OUT15/20634

Thank you for your email of 27 July concerning the review of the Response to Submissions (RTS) for the proposed Drayton South Coal Project.

The Department of Primary Industries (DPI) has reviewed the RTS provided by Hansen Bailey (July 2015) and advises that the majority of issues have been addressed.

Figure 7: Agricultural Land Reserve – Drayton South

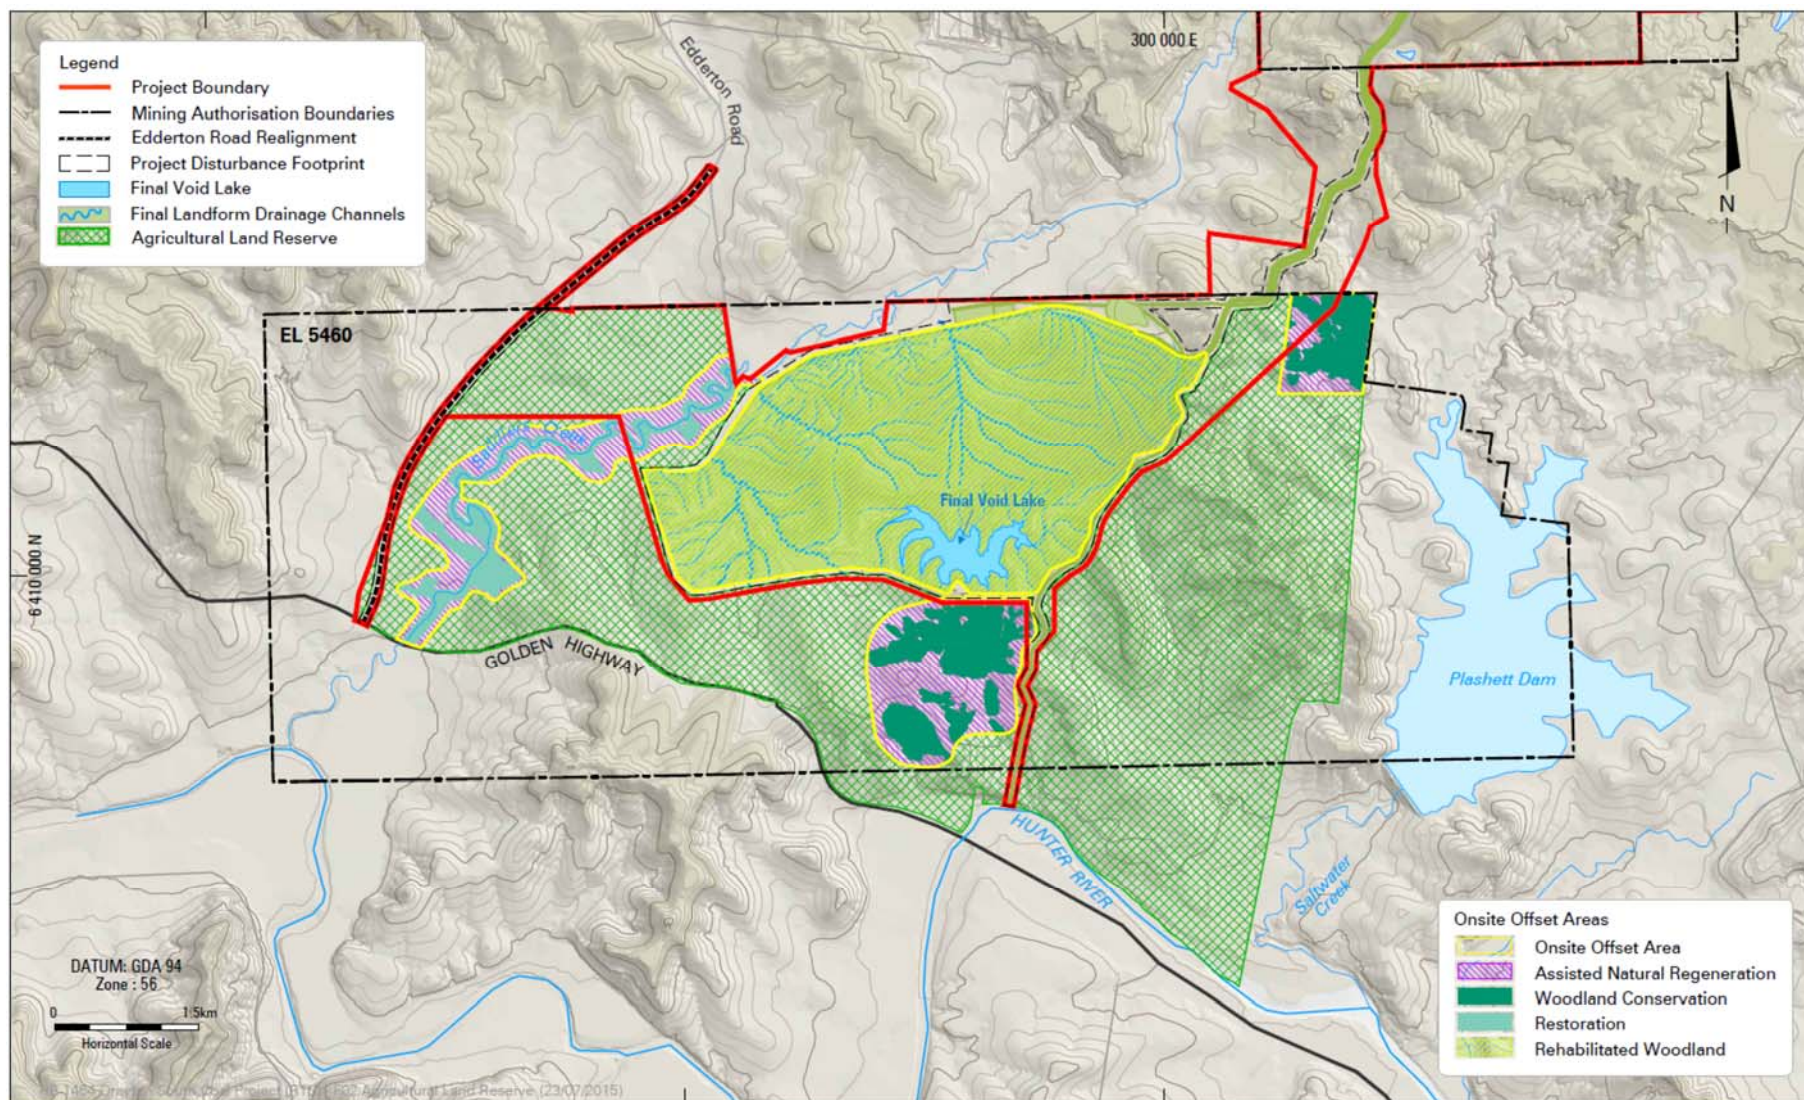
With regard to mitigation of agricultural impacts, the proponent indicates that most of their efforts towards mitigation will be in the creation of an Agricultural Land Reserve on 2700 ha of Anglo owned land (the properties Plashett and Bowfield) outside the mine area. Although the associated land use strategy includes an objective to increase agricultural productivity, this objective is not directly associated with the loss of productivity on the mine area and so cannot yet be considered as mitigation.

It is recommended that the Agricultural Land Reserve be maintained at current levels of production as a matter of course and that any increases be documented as proof of mitigating lost agricultural productivity on the project site. It is also recommended that a consent condition is applied such that an increase in production of the Agricultural Land Reserve is equal to or greater to the loss of production of the Drayton South Coal Mine footprint.
